Letter No. **A2/23345/90**

Sub: MMDA - Planning Permission - Construction of Residential building **Ground floor & First floor** in Plot No. **T.S.No.42** at S.No. **First floor** of **Kodambakkam** village - Approved - Regarding.

site plan

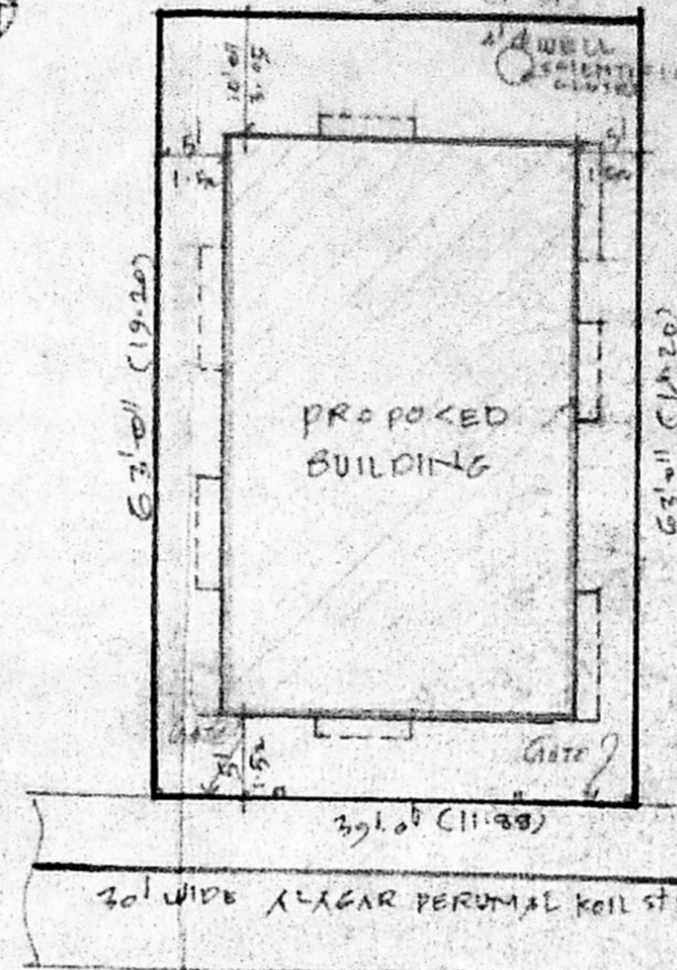
2. In this connection, you are requested to remit a sum of Rs. **800** /-(Rupees **eight hundred only**) towards Development charges for land and building and Rs. /-(Rupees ) towards Regularisation charge by ~~two~~ separate Demand Drafts of a Nationalised Bank in Madras City drawn in favour of the Member-Secretary, MMDA, Madras-8 and submit them at MMDA office Cash Counter between 10.00 A.M. and 4.00 P.M. within 10 days of the receipt of this letter. After remitting the said amount, you are requested to submit the duplicate receipt to Area Plans Unit and furnish ~~an affidavit in Five Rupees Stamp Paper duly attested by Notary Public as per the format enclosed.~~ Planning permission application will be returned unapproved if the amount are not paid within the stipulated time. **You are requested to furnish revised plans (6 Nos) showing 2 gates in front.**
